## **SUBMISSION AS THE LOCAL PLANNING AUTHORITY**

1.1. This submission is made in response to the action points and additional information as requested by the ExA during the examination period for ISH1 – ISH5 which took place between the dates of 3<sup>rd</sup> December 2024 and 5<sup>th</sup> December 2024 (inclusive). This list should be read in conjunction with the action point documents published by the ExA referenced as EV7-001 (ISH1), EV8-001 (ISH2), EV9-001 (ISH3) and EV10-001 (ISH4). It should be noted that no formal action points were recorded for ISH5. Action point raised as part of the CAH2 is within the Land Owners section of the Council's examination summary submission.

Drawing file: TR010065 / TR010065-000159-TR010065_A46 Newark Bypass_6.2 Figure 5.3 - Air Quality Constraints Dust Buffer.pdf

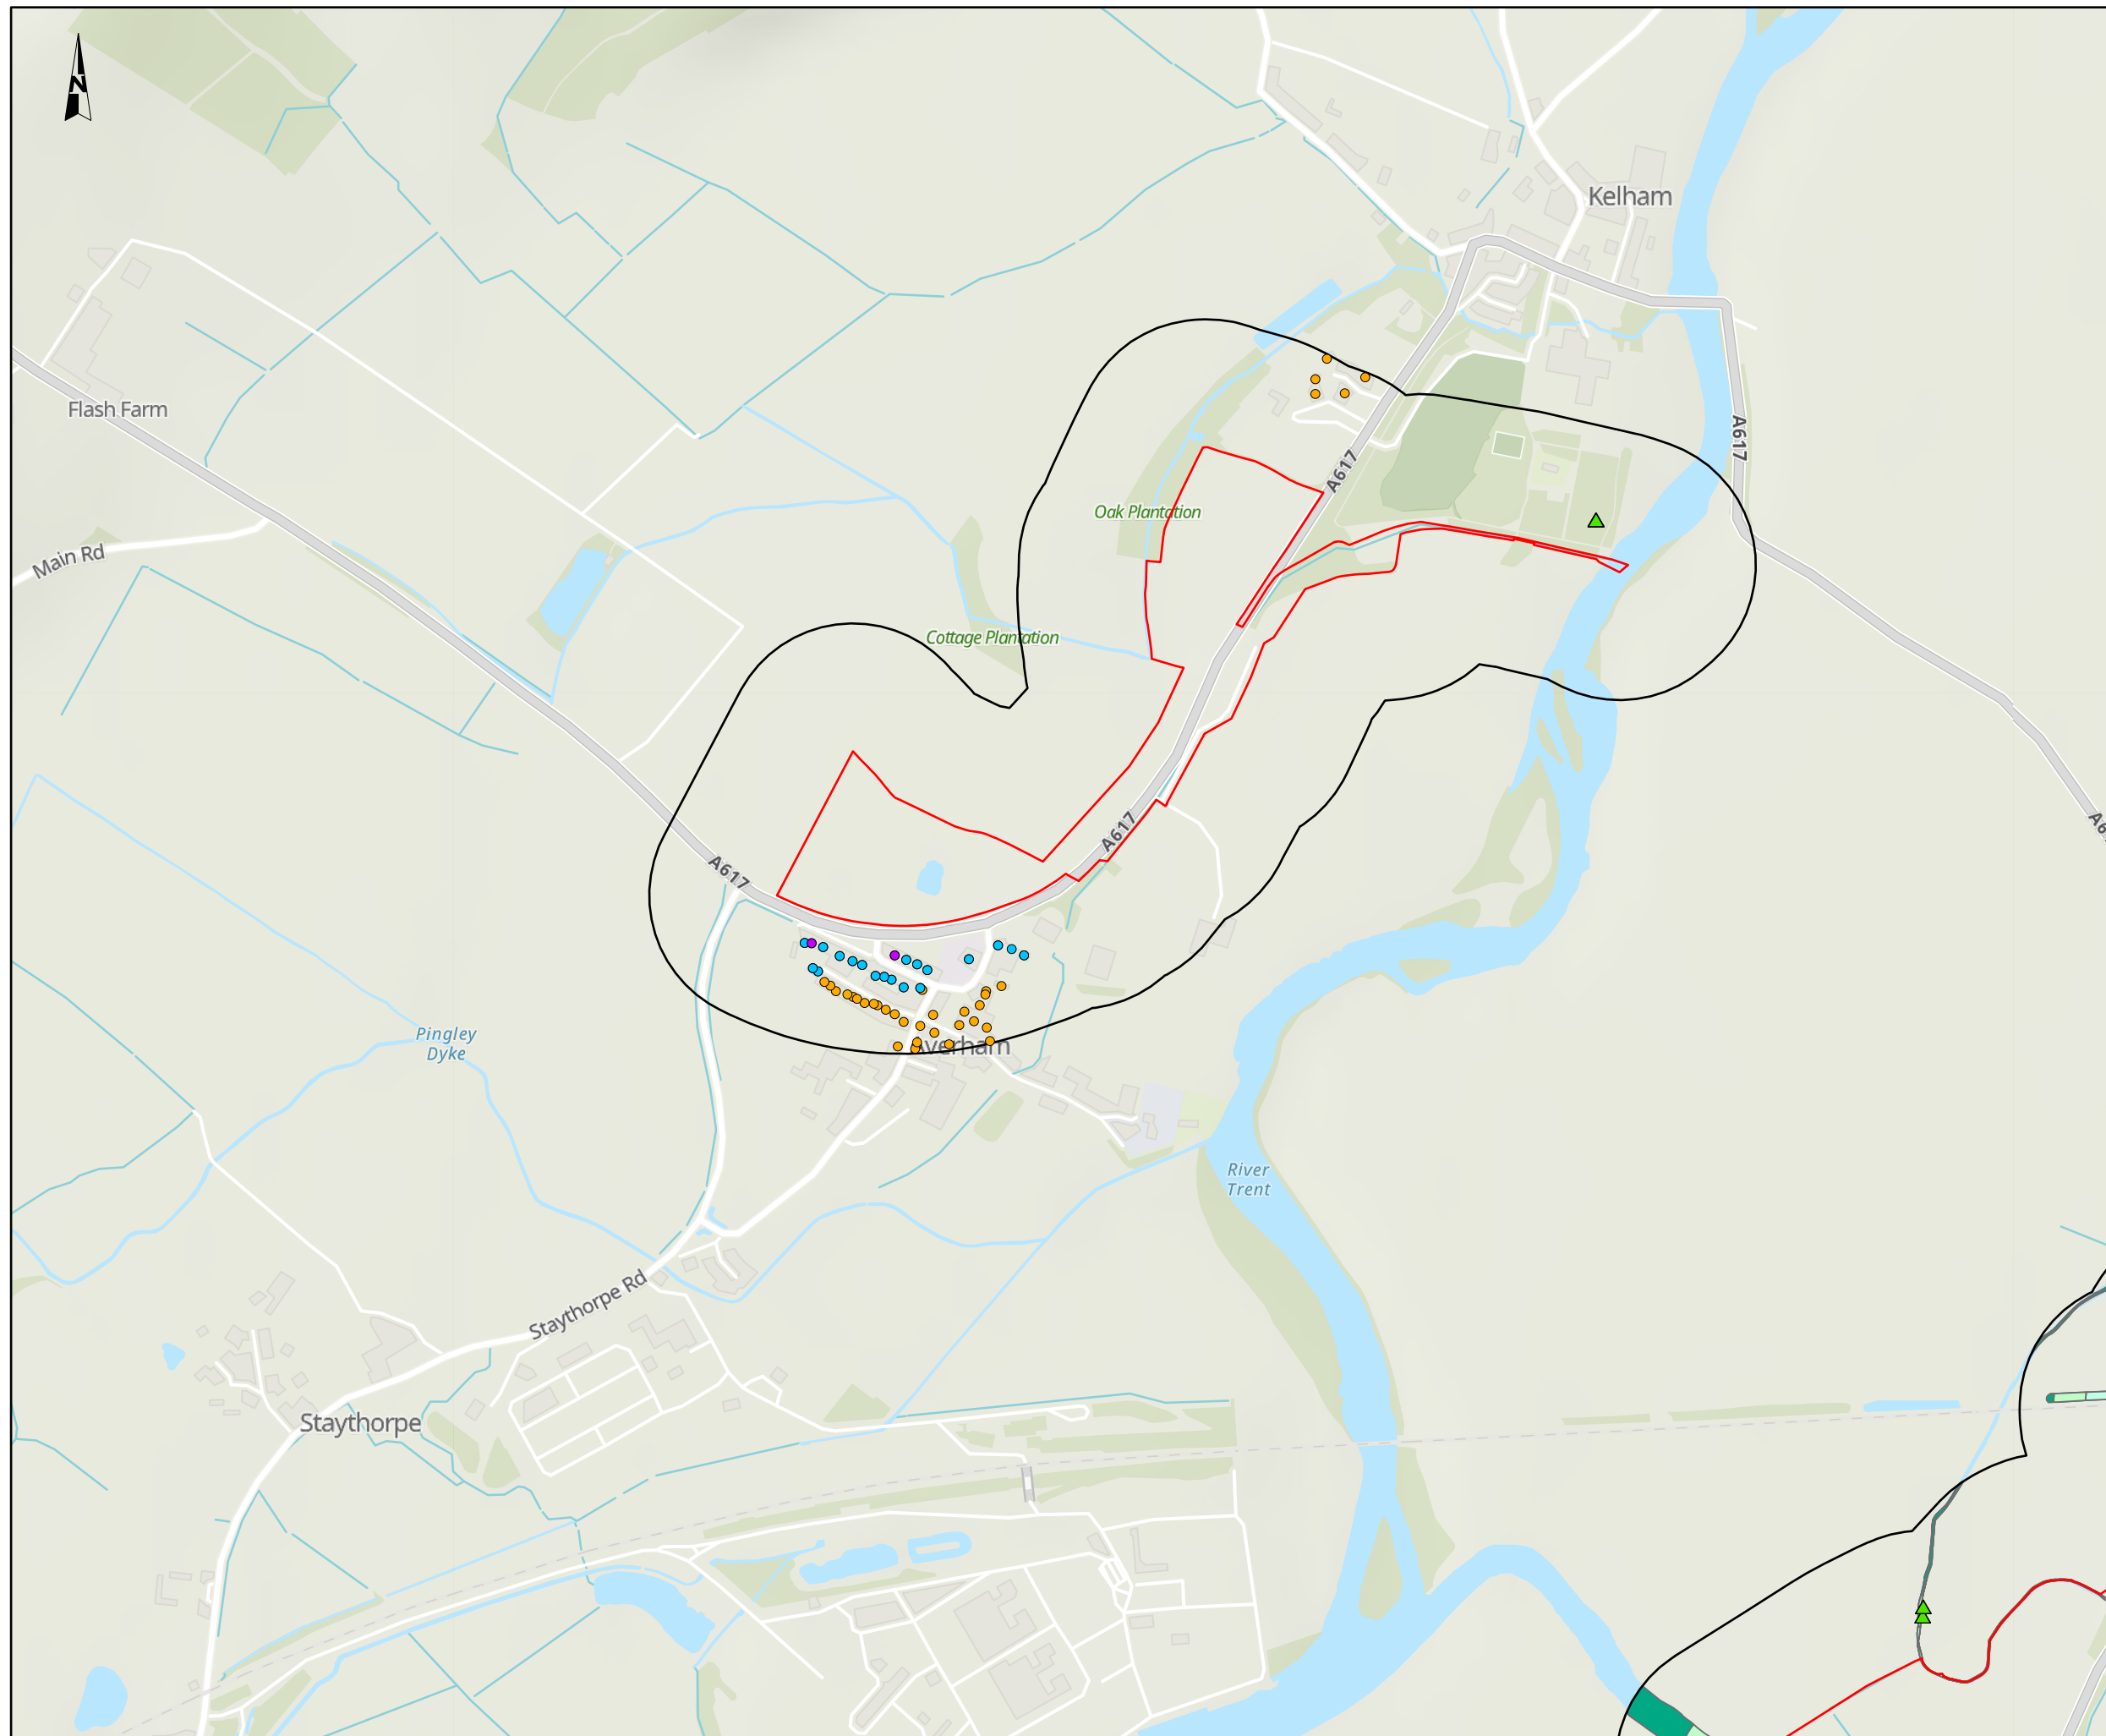
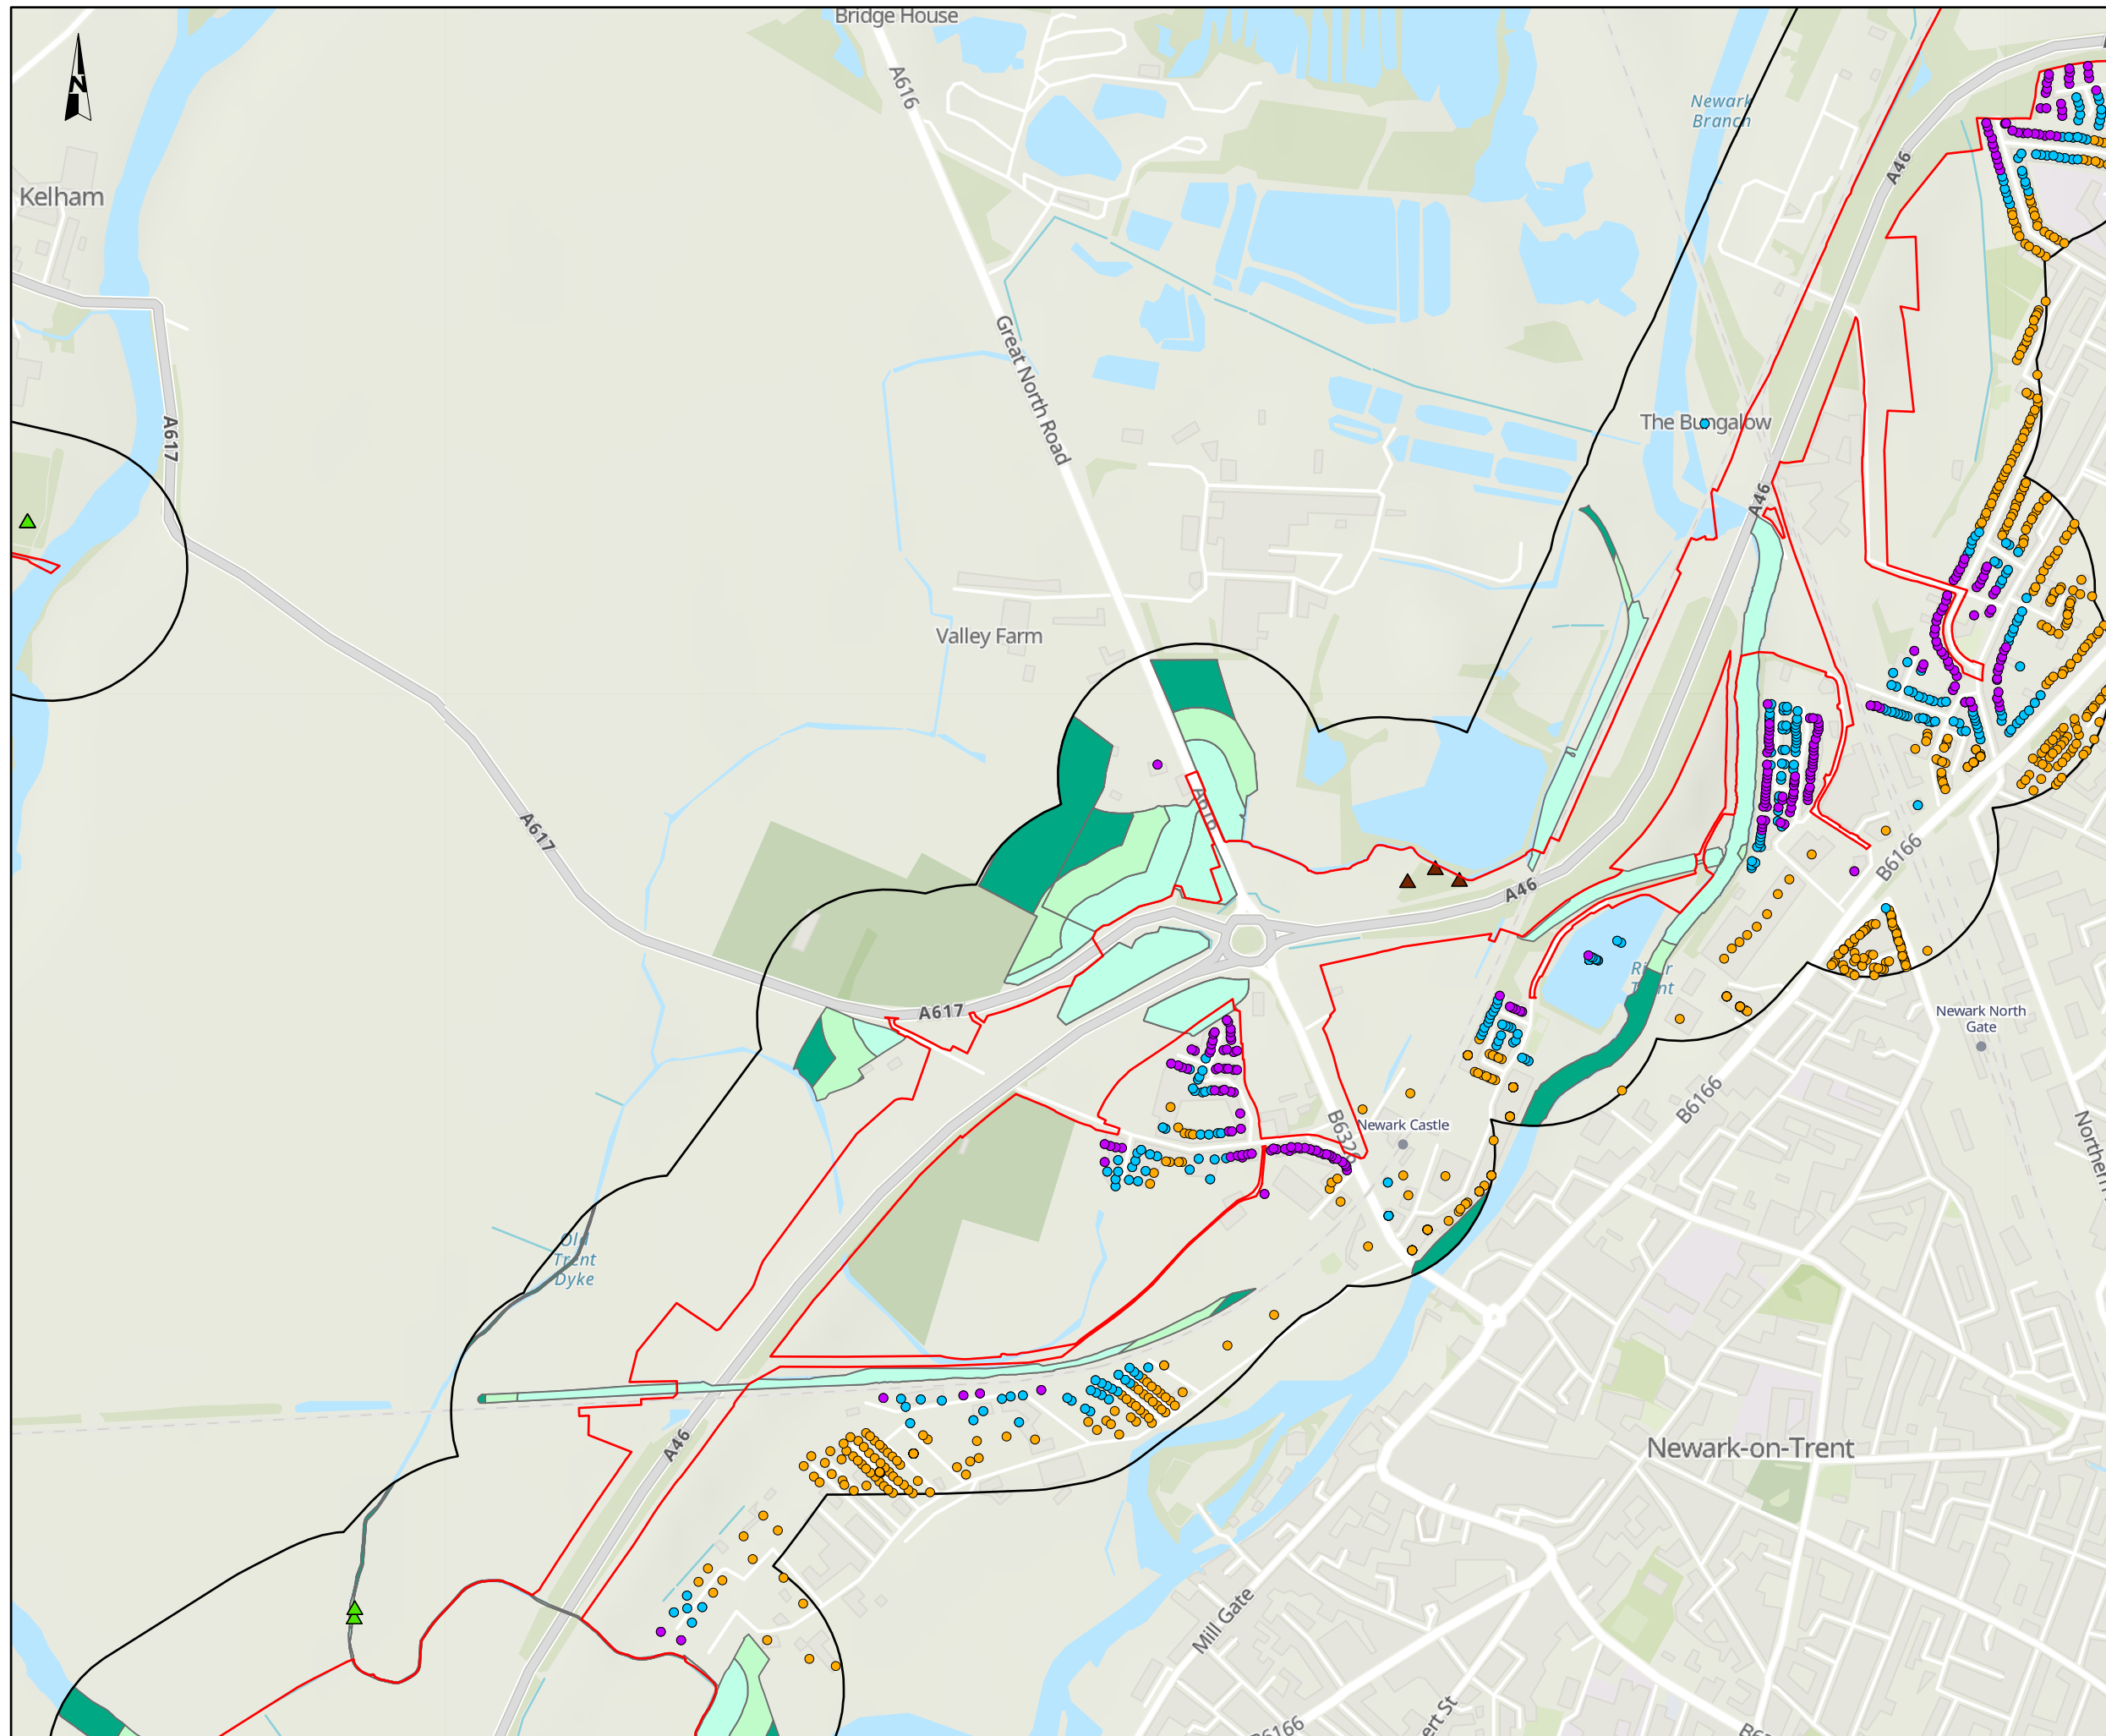
- Table 1-3 the mitigation measures concerning 'preparation and maintaining the site' are repeated.
- A figure would be useful to illustrate the locations of the higher risk areas as detailed in Table 1-2. It is acknowledged that in Environmental Statement, Figures 5.3 [TR010065/APP/6.2], receptors are identified which are located within 100 m of the site boundary; however, it appears more information is now available to identify receptors within 100 m of specific works. Therefore, an updated figure would be helpful to understand where additional specific control measures will be implemented.
